Elizabeth Elenius, Convenor,  
9C/2 Bowman Street,  
PYRMONT NSW 2009  
[eelenius@bigpond.net.au](mailto:eelenius@bigpond.net.au)  
0409 552 117  
02 9571 9727

30 April, 2018

## Glebe Island Aggregate Handling and Concrete Batching Facility

Figure 16 Proposed layout of the Glebe Island Concrete Batching Plant

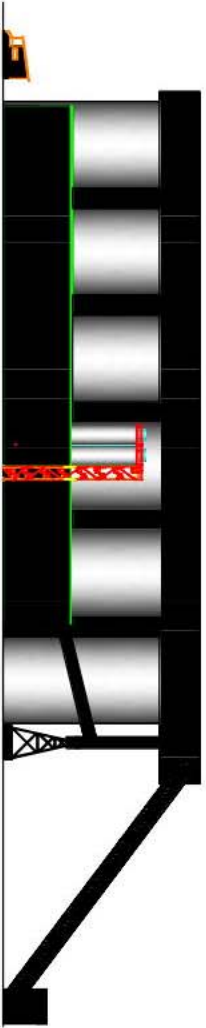
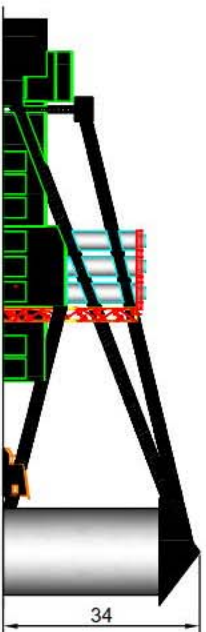
The proposed mitigation measures include a suggestion that the core structure of the silos be left open as the currently proposed roof will adversely affect those using the Anzac Bridge. We oppose this suggestion as it could lead to a decrease in air quality for those living and recreating close to the plant.

***Recommendation 13** – The silos should be fully enclosed, including with a roof structure to reduce possible air quality impacts on nearby residents and park users.*
